**PROPOSED DEMOLITION OF THE EXISTING DWELLING AND  
OUTBUILDINGS, CONSTRUCTION OF NINE NEW DWELLINGS  
(RESUBMISSION FOLLOWING REFUSAL OF APPLICATION  
S.20/1584/FUL)**

**AT 4 WHITEHOUSE PARK, CAINSCROSS, STROUD,  
GLOUCESTERSHIRE, GL5 4LD**

**PLANNING STATEMENT**

TYPE A BUNGALOW LAYOUT

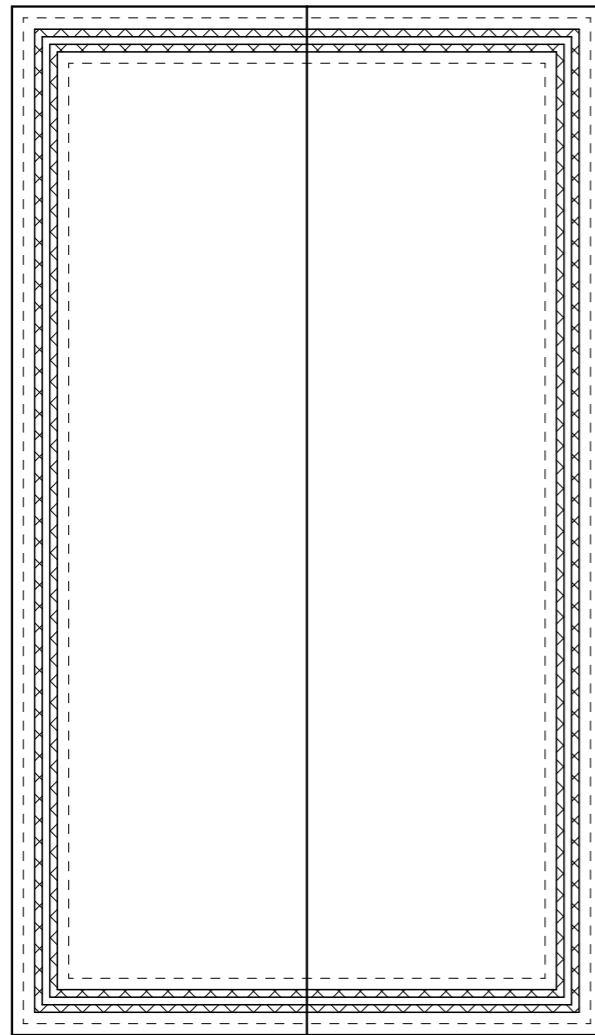
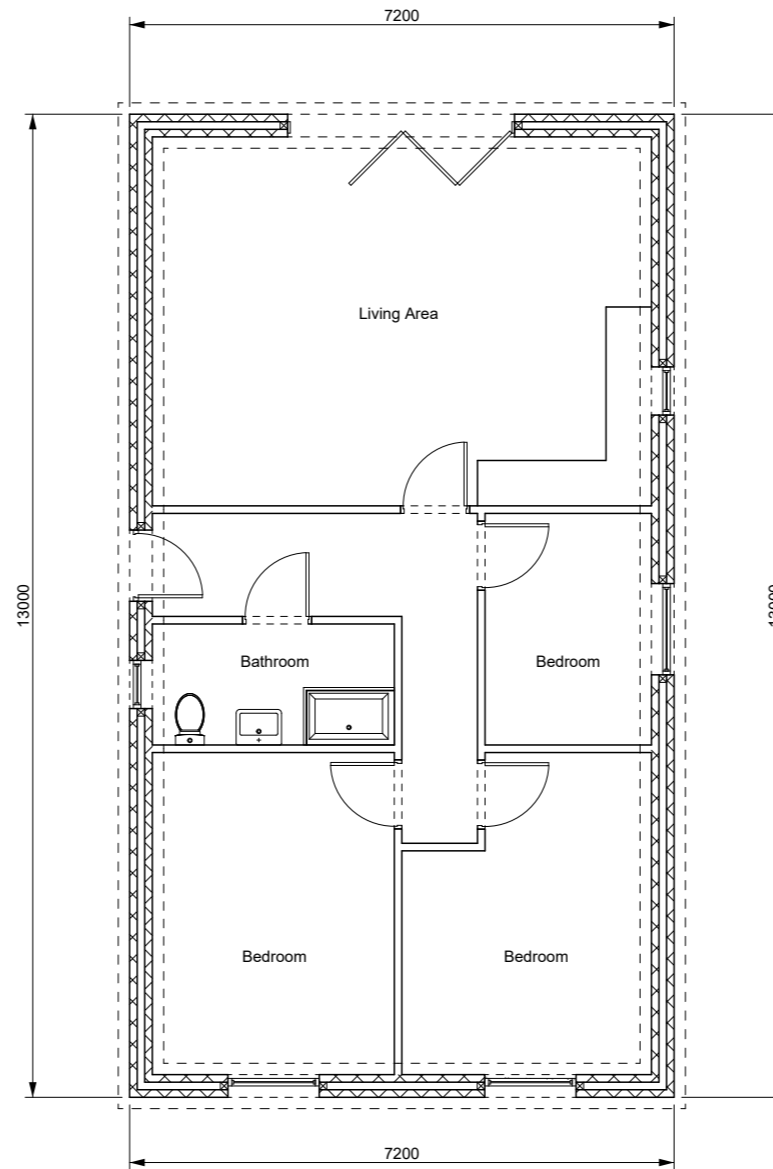
*The new dwellings on plots 1 & 9 have a prominent large and long gable form. The window to wall ratios and wall to roof ratios are considered to be out of proportion, resulting in the buildings appearing somewhat top heavy and bulky. The gable to the west elevation does not relate well to the main bulk of the building, it appears at odds and contrived. As with the dormer window proposed to the east elevation that also does not relate or fit well within the roof slope. As such, the proposed units would not blend with the surrounding built form and are therefore not considered acceptable.*

- 7.11 The Officer's Report for Application S.20/1584/FUL states as follows.  
*“due to the relatively limited separation distance between the properties, plot 1 and plot 9 face one another with clear glazing. The*

*separation distance is approximately 11.5m. Plot 8 and plot 3 & 4 face one another with clear glazing. The separation distance is approximately 15M and plot 1 overlooks No.2 Whitehouse Park with clear glazing. The separation distance is approximately 9M. As such, there would be a level of overlooking that would not be considered acceptable and would not comply with the Councils Residential Design Guide. While it is noted that these windows could be obscured to seek to protect the amenity of neighbouring residents, this would not be considered to be a well-designed scheme and would then be to the detriment of the occupier as the rooms would be an undesirable place to be with limited light and view.”*

- 7.5 In response to the above assessment, plots 1 and 9 will now comprise single storey bungalows, thereby reducing scale and removing dormers. As shown below.

7.12 Regarding the relationship between plots 1 and 9, the revised plans completely address the issues raised. The only facing windows will be a small bathroom window, which will be obscurely glazed. The main windows will be on the gable ends. Similarly, with plot 8 there will be no windows in the front elevation thereby addressing the concerns regarding plots 3 and 4. And in terms of the relationship between plot 1 and No.2 Whitehouse Park, the opening on the rear elevation will be minimal and now all at single storey level. Furthermore, the proximity between these dwellings is exactly the same as has already been approved.

TYPE B HOUSE LAYOUT

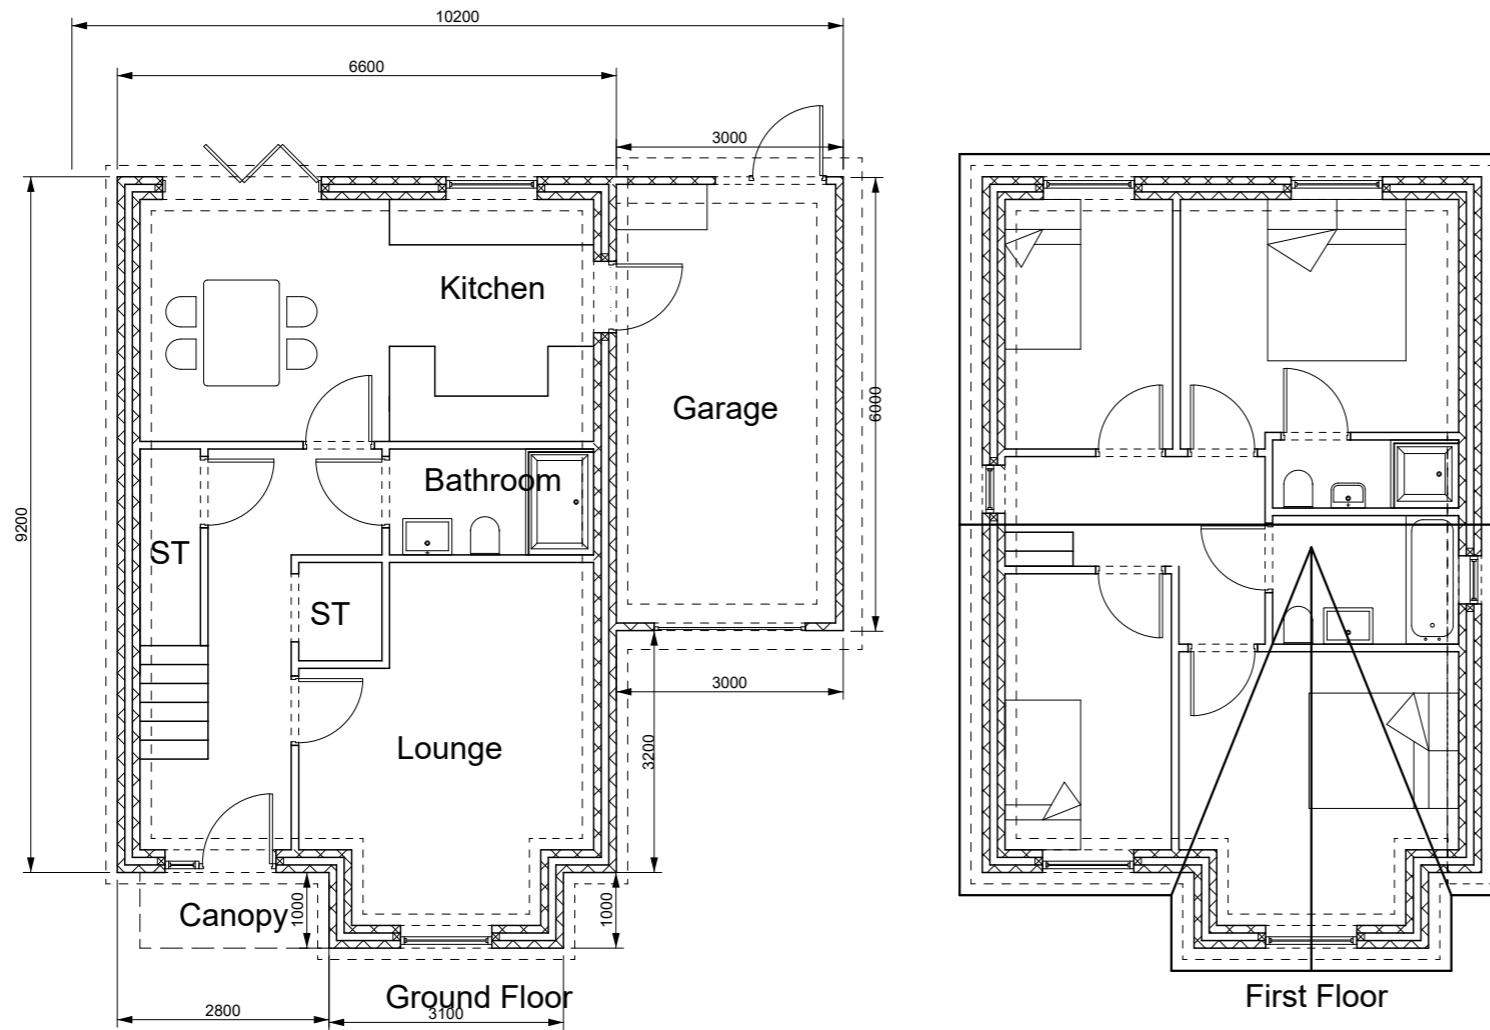
- 7.6 The officer's report goes onto state that *"The design of the new dwellings proposed on plots 2, 3 and 4 also appear out of proportion. While the window to wall ratio appears to be balanced, the wall to roof ratio is out of proportion. The pitch of the roof is too shallow which has resulted in the proportion of roof appearing limited and the wall appearing tall. Again, the proposed units would not blend with the surrounding built form and are not considered acceptable."*

- 7.7 In response to this statement, the design of the house type for plots 2, 3 and 4 has been revised. This represents an improvement with a better overall proportion and a slightly steeper pitch to the roofs, as demonstrated below.
